Reference:	H05-0294-23	Date of Decision:	8th June 2023
Applicant:	Mr A Wright 14 Cross Street Fleet Spalding PE12 7BD		
Location:	Adj. 14 Cross Street Fleet Spalding		
Description:	Proposed dwelling & detached garage

South Holland District Council hereby give notice that this application has been REFUSED for the above proposal for the following reason(s):

North Elevation (1:100)

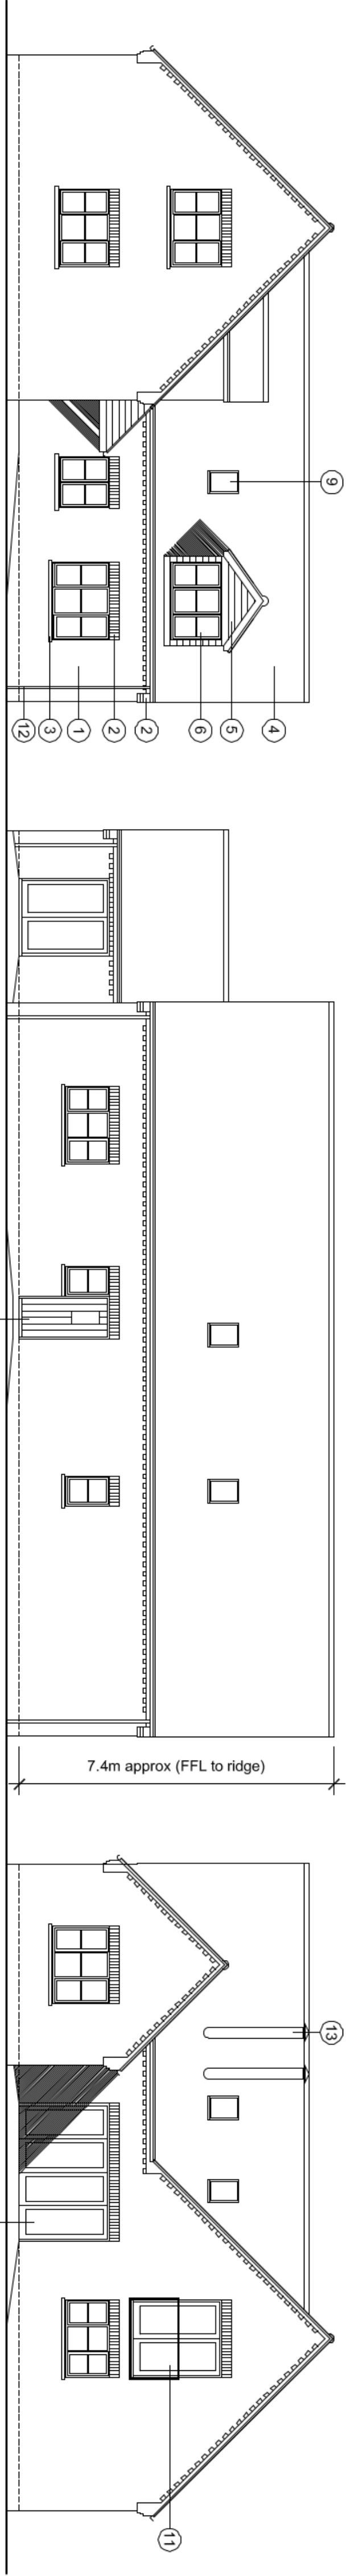
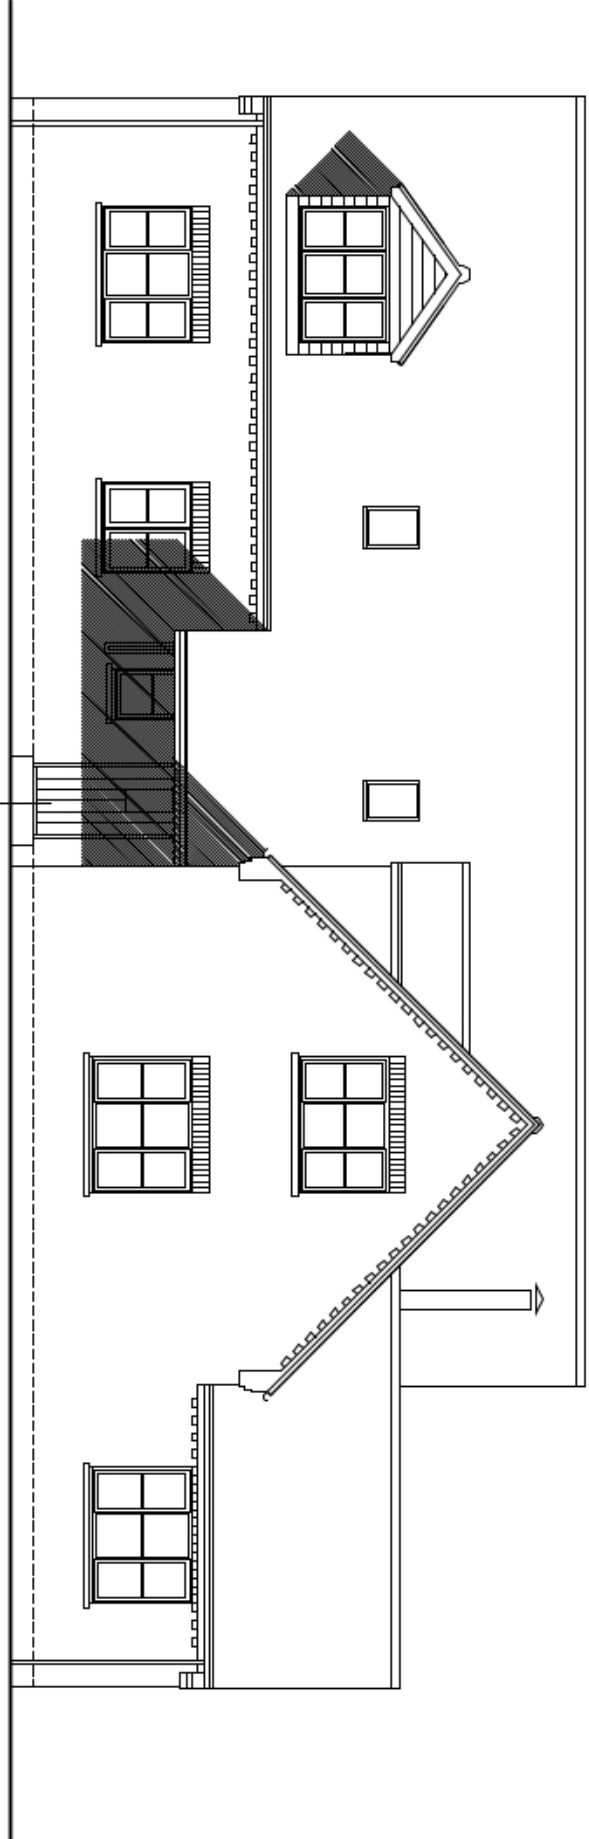
The scheme proposed parking to the rear of the site which results in an unacceptable relationship and noise disturbance for the occupiers of the existing dwelling at no.14 Cross Street. Furthermore the proposed dwelling given its height and close proximity to the eastern boundary would result in overbearing impact and unacceptable overshadowing on no.18 Cross Street.

Proposed Block Plan (1:250)

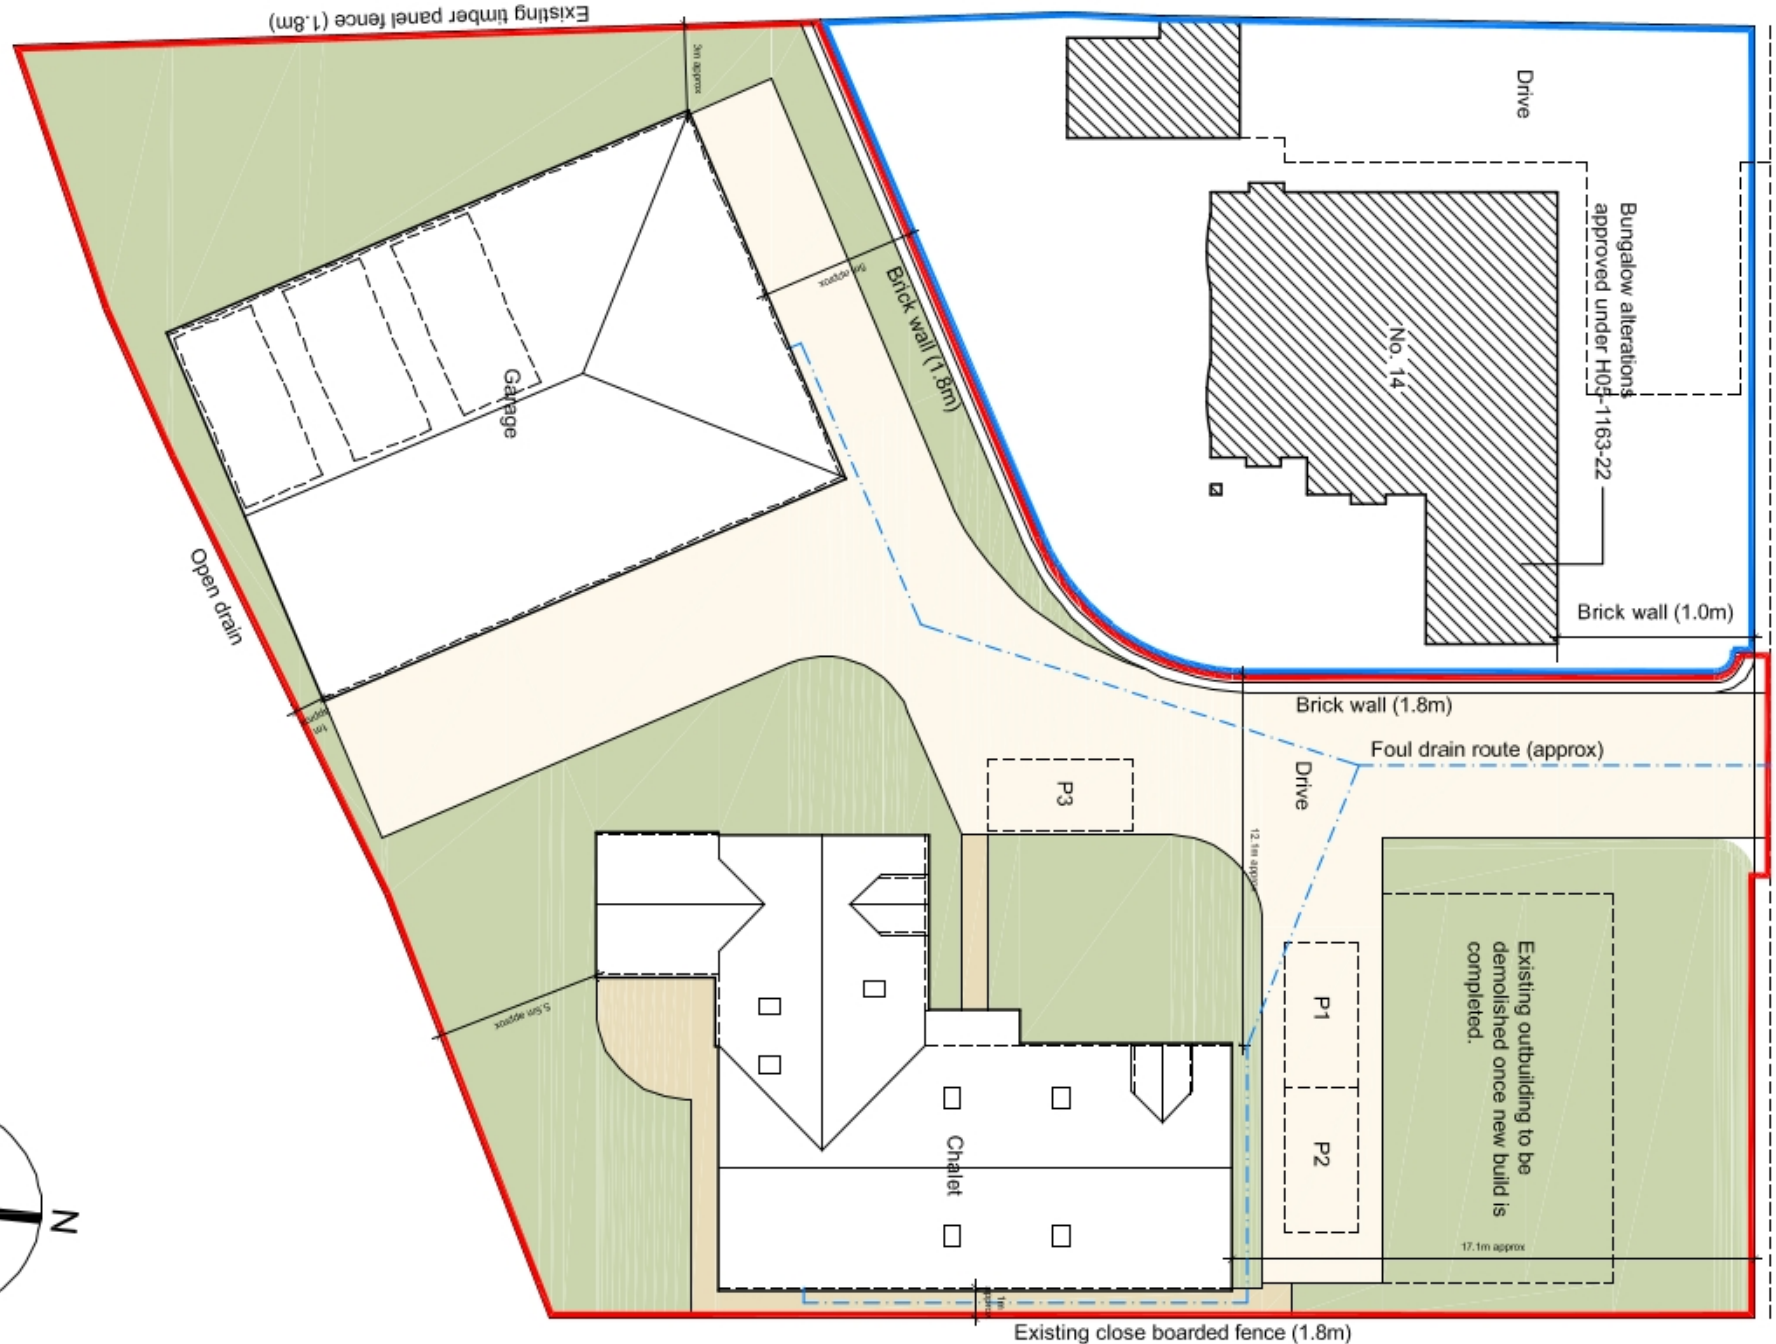
- 1 The site is inside the Fleet Settlement Limit as defined in the South East Lincolnshire Local Plan (SELLP), 2019. However, the proposal would result in overdevelopment and constitute a cramped and inappropriate form of development that would be out of character with the area. It would also leave little outdoor amenity space for the existing dwelling at no.14 Cross Street.
